Subject: RE: Hornsby Hospital MOD 1

Please provide some information as to why the unit can't be enclosed, instead of such a high wall being provided?

Service Yard
1:100
WHLAR MW 1011

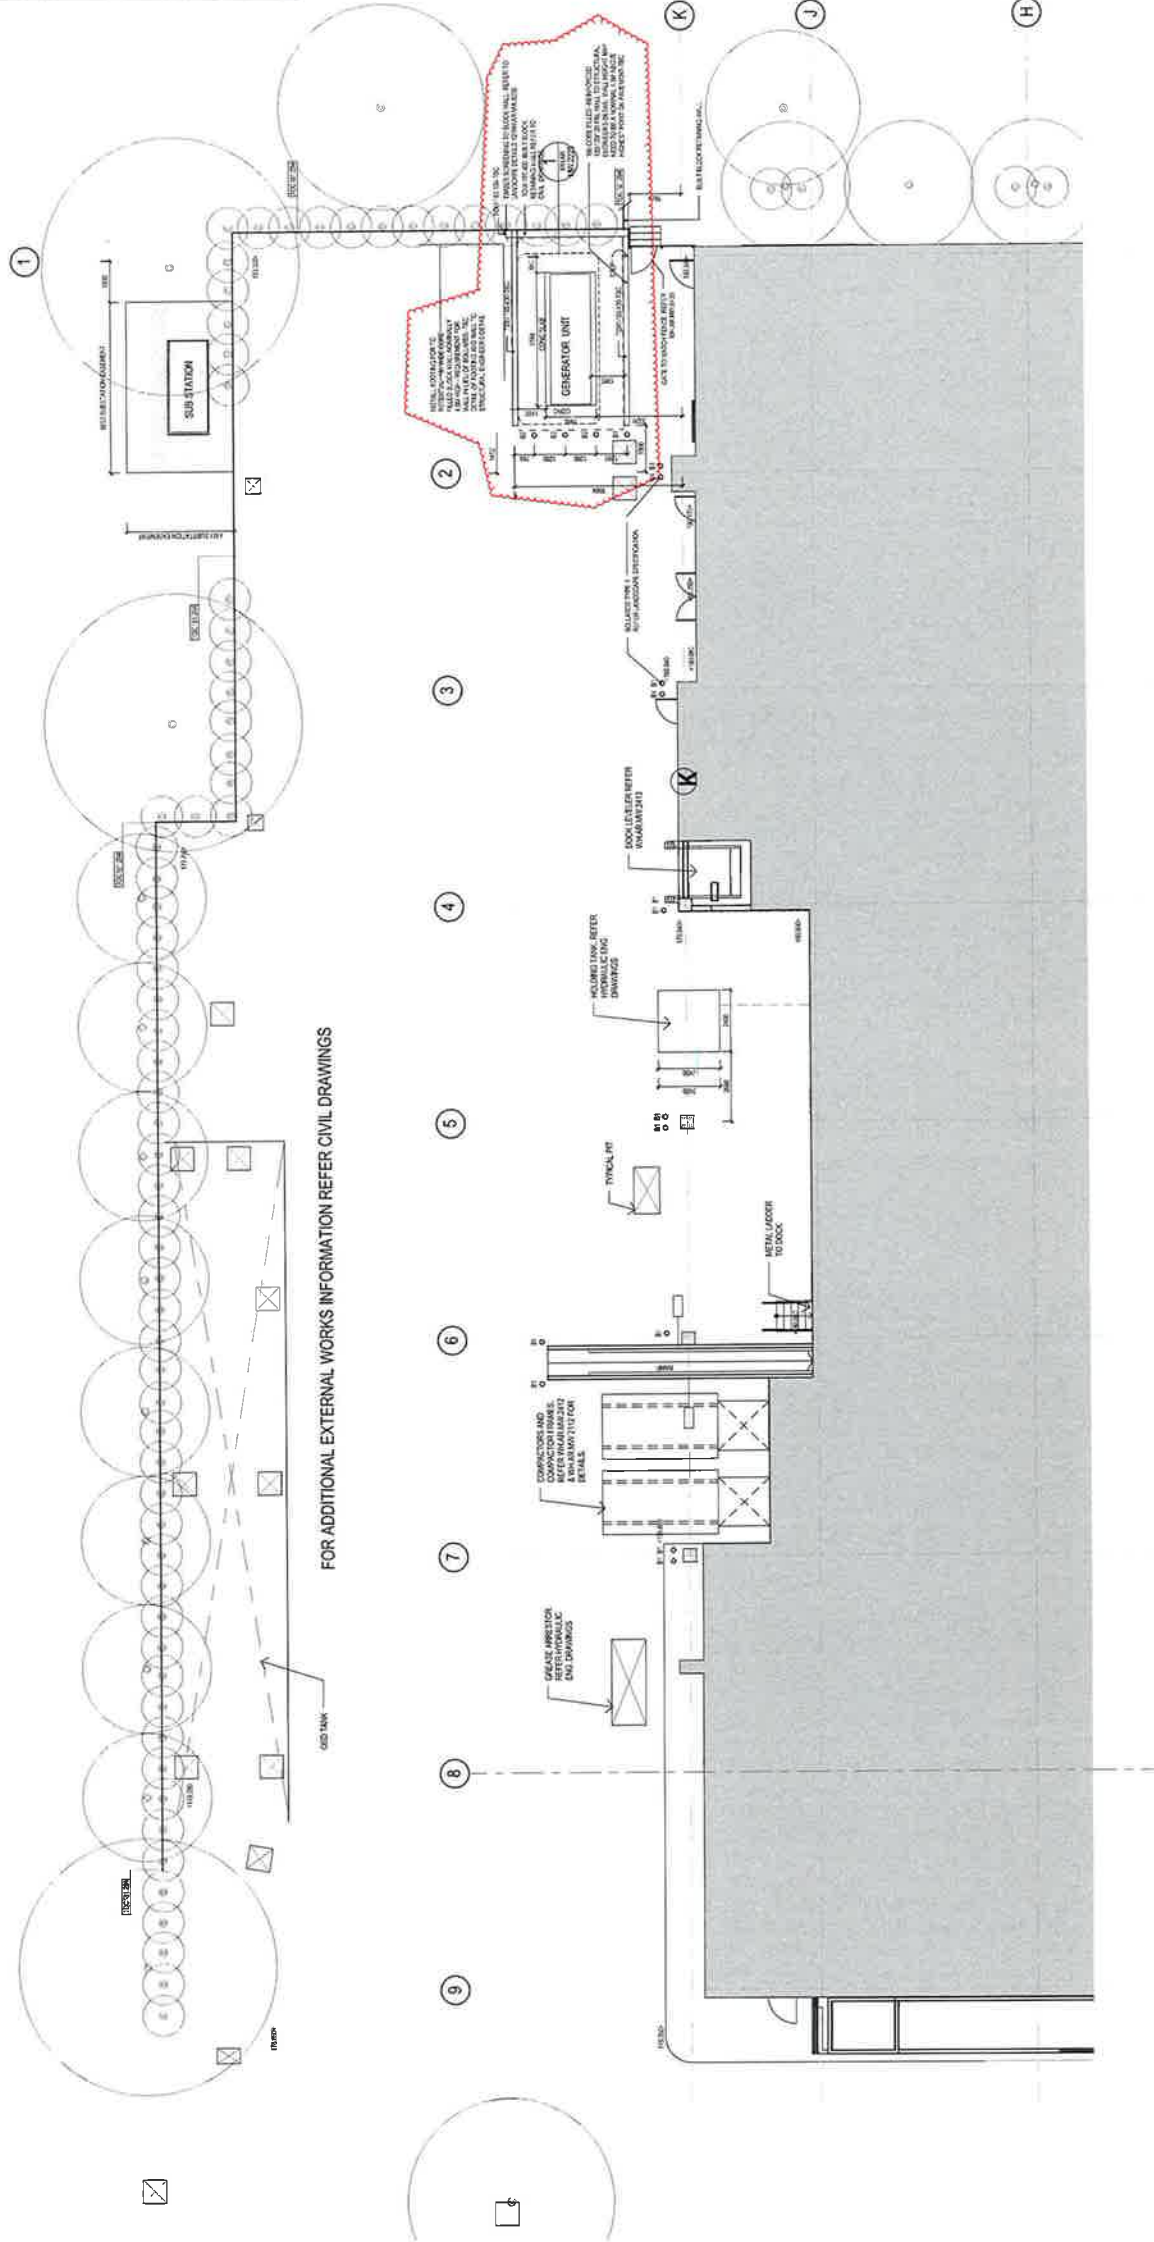
Please provide an updated site plan showing the changes to the generator.

3. TTW.CV.MW_0004-X as-built attached.
